**Consultation Response from: KC Environmental Health (Pollution & Noise Control)**
**2025/92971 - Grange Moor Coachworks, Barnsley Road, Grange Moor, Huddersfield, WF4 4DR**

**Variation of conditions 2 (plans) and 13 (replacement wind turbine) on previous permission 2023/90668 for demolition of existing buildings. Erection and operation of a single building comprising a Sui Generis land use limited to the purpose of storage, assembly, sale and distribution of custom-built computers, laptops and their components as well as any associated development (those being a replacement wind turbine, utility provision, drainage, access, hard and soft landscaping) within the red-line boundary alongside business operations pursuant to the effective administration of the Sui Generis use.**

**Responding Date:**  
**07 January 2026**
**Responding Officer:**  
**Mohammed Nasim**
**Responding Ref:**  
**WK202539671**
**Comments**

DECIBEL - Main Result

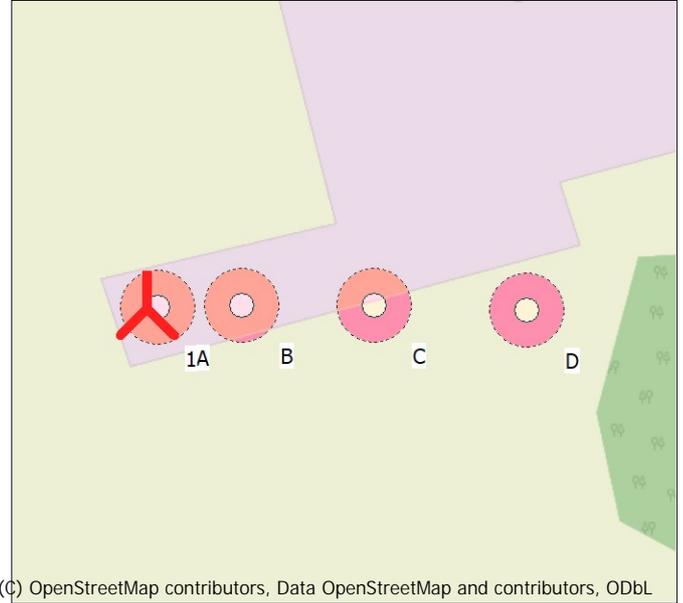
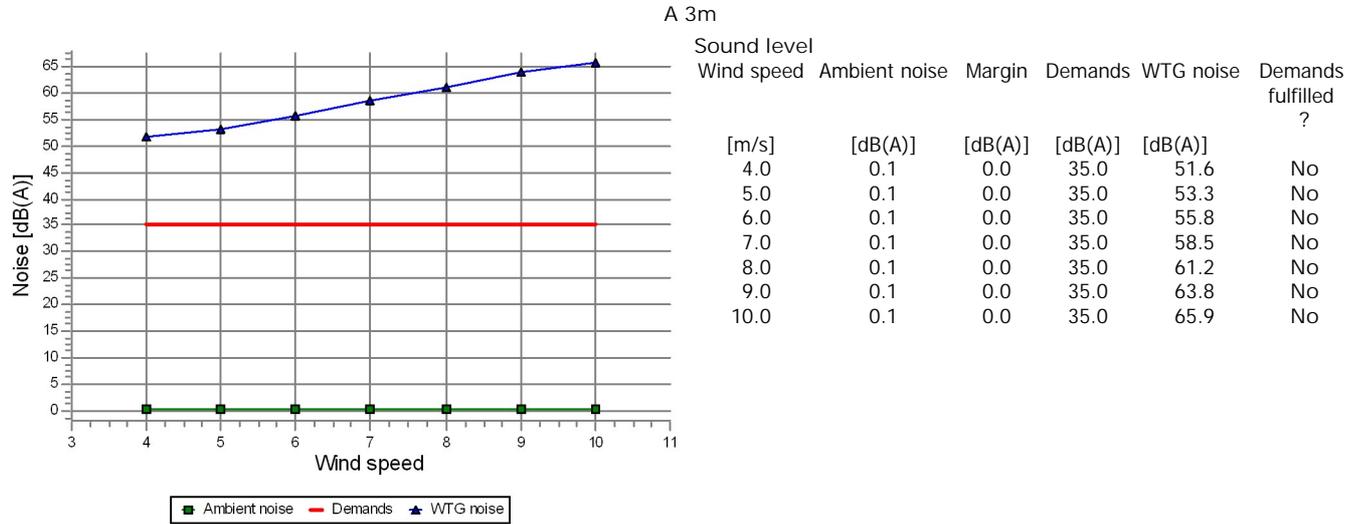
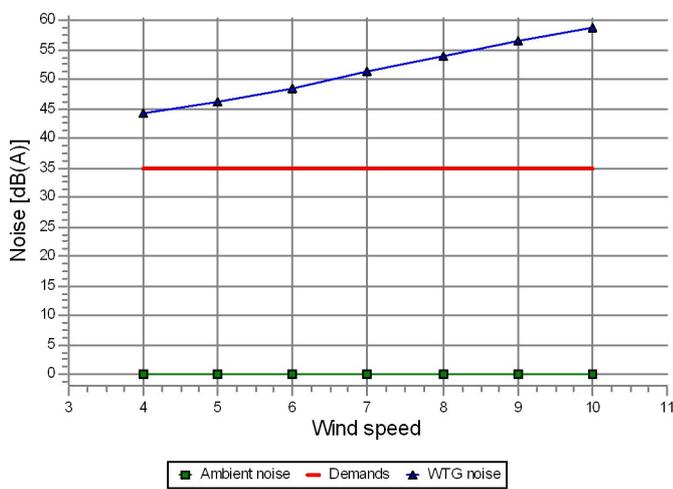
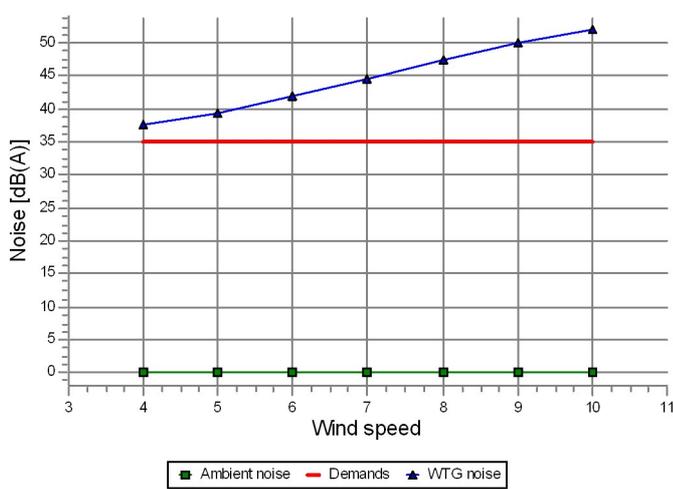
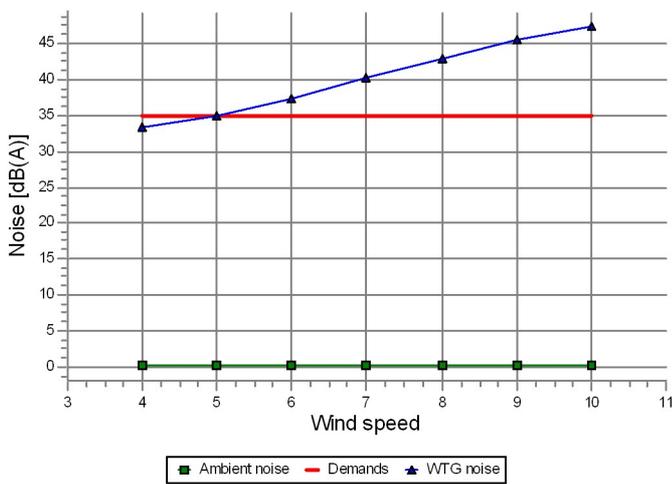
A noise data report from Infinite Renewables Limited is submitted which provides some acoustic data but it does not determine noise levels at the nearest noise sensitive receptor nor distinguish between daytime and nighttime periods. Therefore, this is rejected. A Noise Impact Assessment is required prior to determination.

The noise assessment shall be carried out by a suitably competent person and include the following details:

- a) an assessment of all noise emissions from the proposed development
- b) details of existing background and predicted future noise levels at the boundary of the nearest noise sensitive premises
- c) a written scheme of how the occupants of the above-mentioned noise sensitive premises will be protected from noise from the proposed development including details of all necessary noise attenuation
